**From:** Contact Centre (CRM) <contact@ribblevalley.gov.uk>  
**Sent:** 28 December 2023 23:40  
**To:** Planning  
**Subject:** Planning Application Comments - 3/2023/0930 FS-Case-572605030

**Planning Application Reference No.:** 3/2023/0930

**Address of Development:** Clayton Manor Ribchester Road Wilpshire  
Lancashire BB1 9HU

SIDE ELEVATION

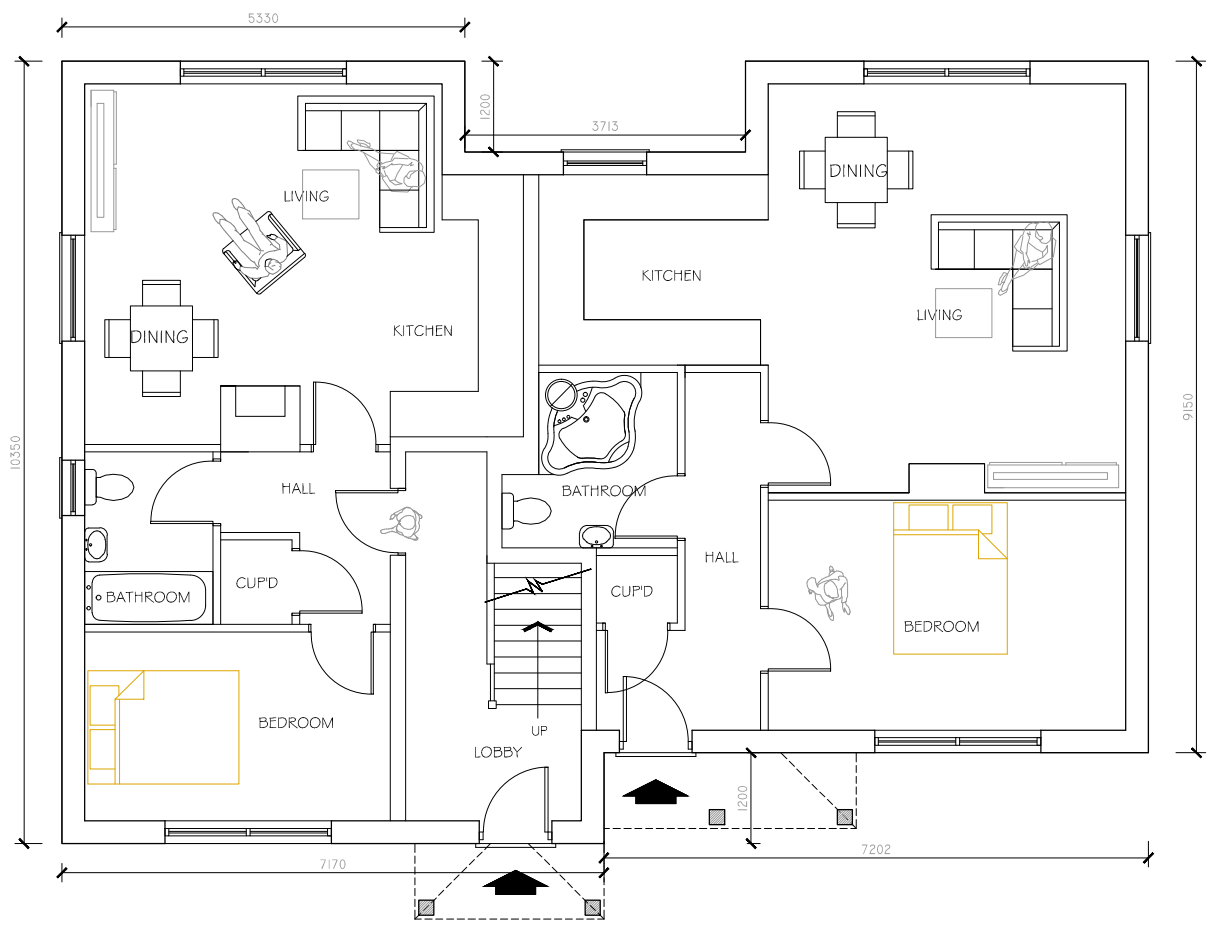
- Side elevation windows, [REDACTED]
- There will be an impact on light [REDACTED] as a two story building will be higher than any existing height line
- Due to the slope of Knowsley Rd and the angle of vehicles exiting the proposed gateway, at night car headlights will [REDACTED]
- I have a concern about safety at the junction between Knowsley Rd and Ribchester Rd having two driveways and a junction all on a bend in the road.

Drawing Title
PROPOSED CLAYTON MANOR LODGE SITE LAYOUT

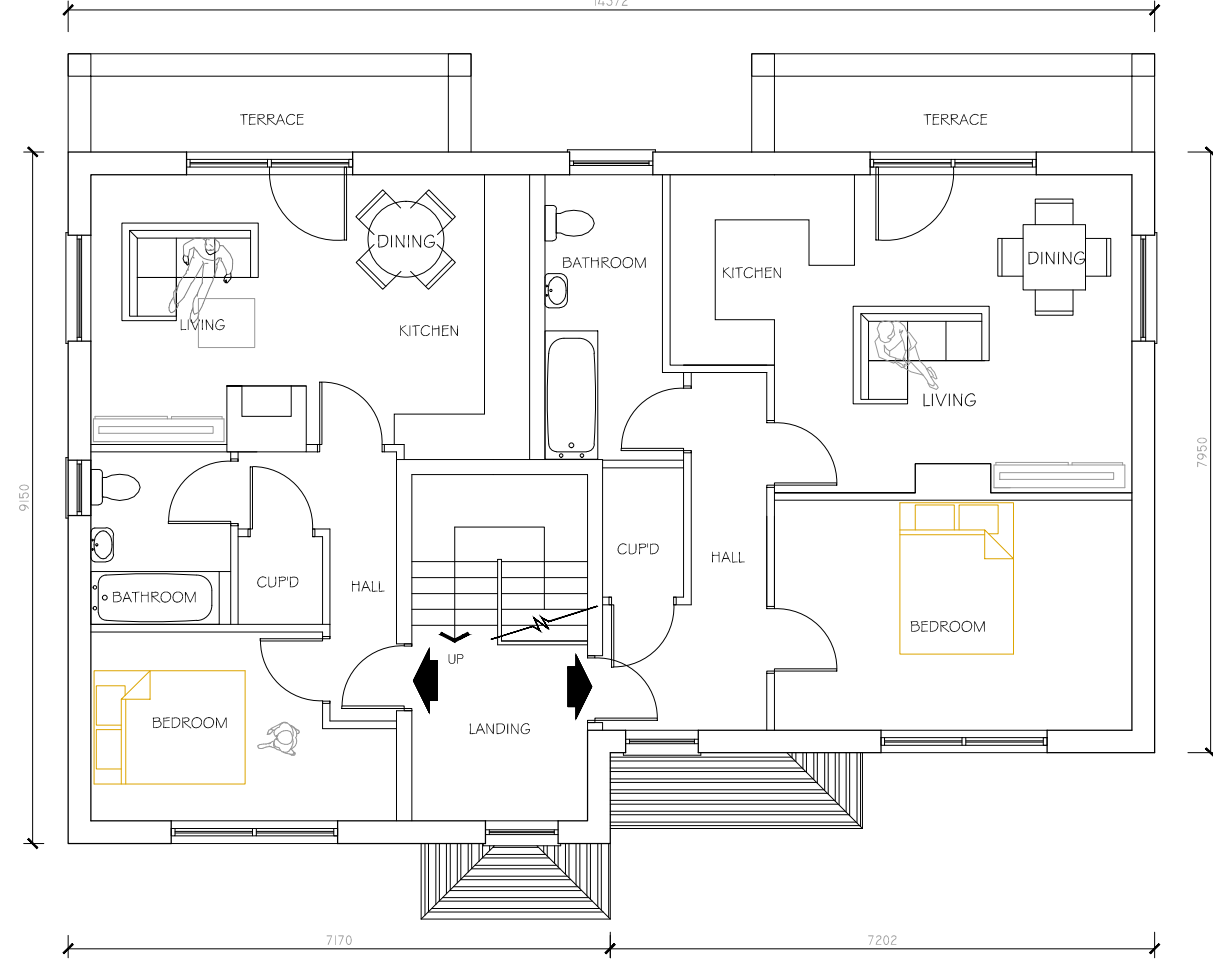
- I'm concerned that an additional 3 parking spaces for 4 flats, each of which could have two cars plus visitors, is insufficient and would result in consistent use of on road parking, with the potential to reduce visibility near a junction on a bend.
- Many of the properties in the area have Covenants applied, restricting changes to, and use of the property and its grounds, please ensure these have been checked and followed.
